Notice of Modification

Section 96(1A) of the *Environmental Planning and Assessment Act 1979*

The Development Consent for the Springvale Water Treatment Project (SSD 7592), granted by the Planning Assessment Commission on 19 June 2017.

Figure 3.1

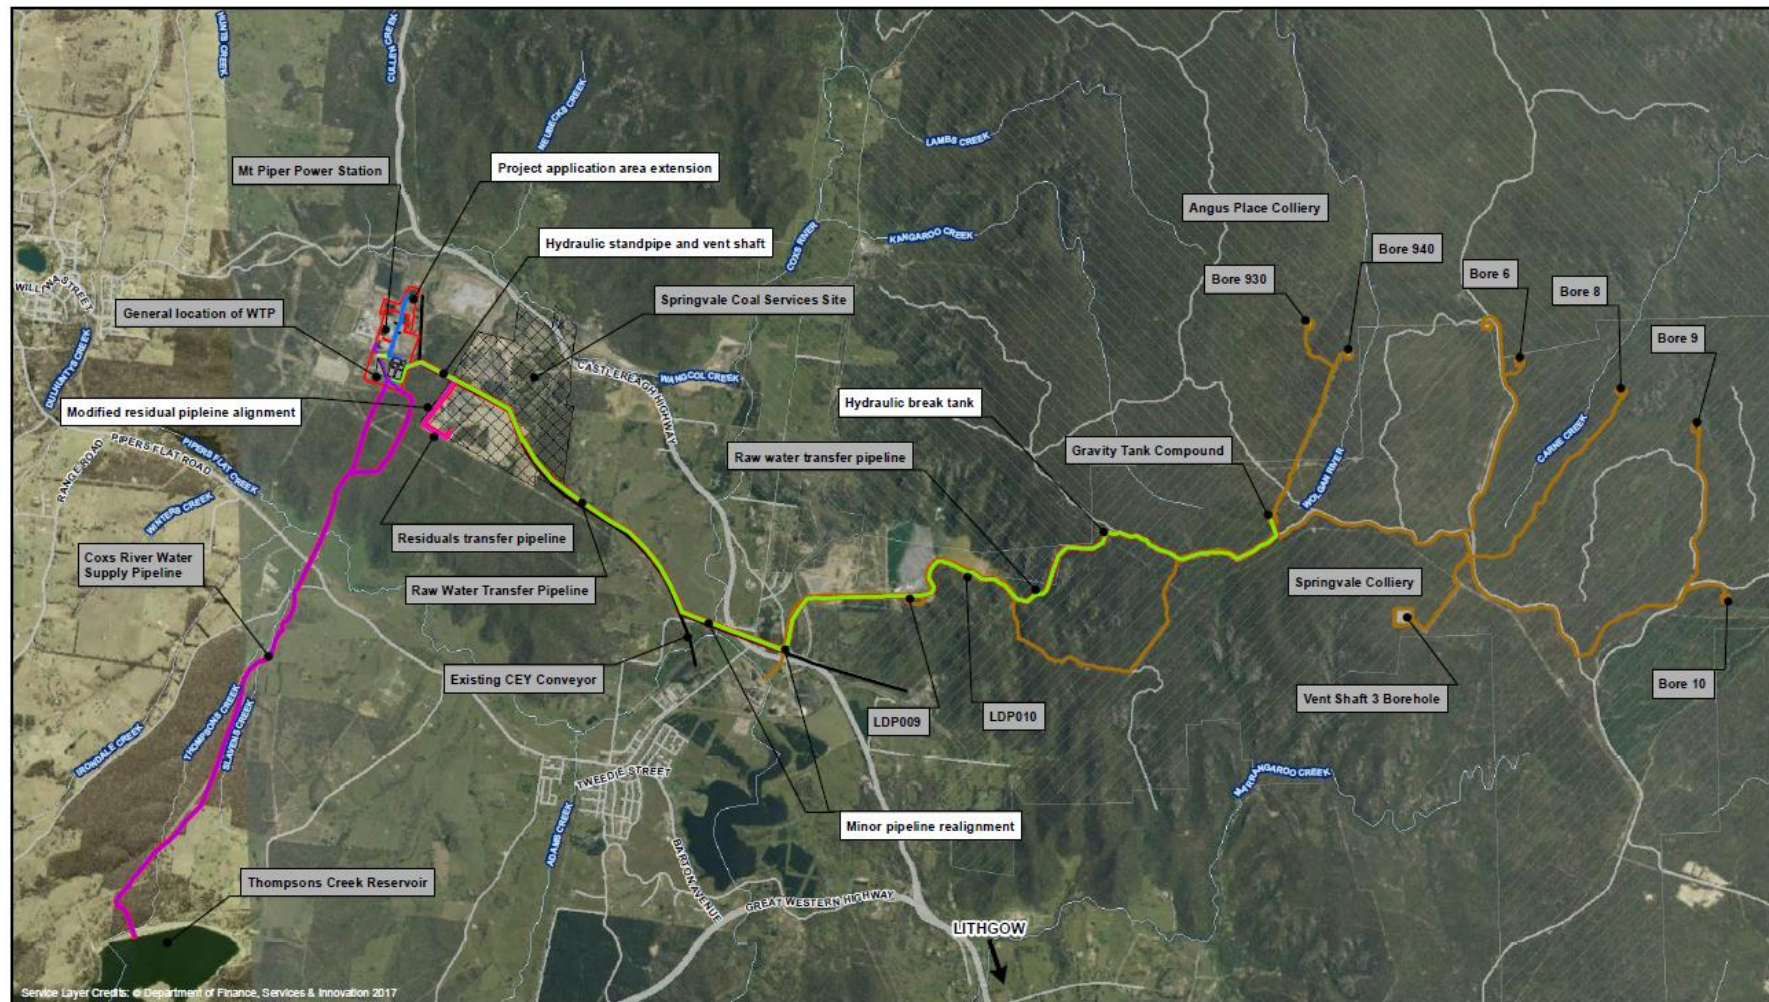
1. In the definitions in Schedule 1, replace the definition for "EIS" with the following:
 - EIS
 - *Springvale Water Treatment Project Environmental Impact Statement* dated September 2016 and the associated Response to Submissions dated December 2016, as amended by:
 - *Springvale Water Treatment Project Amendment to Development Application* (GHD Pty Ltd, December 2016); and
 - *Springvale Water Treatment Project Modification 1 Statement of Environmental Effects* dated November 2017 and associated Response to Submissions dated December 2017.
2. In Appendix 2 Project Layout, delete Figure 1 and insert the figure on the following page:
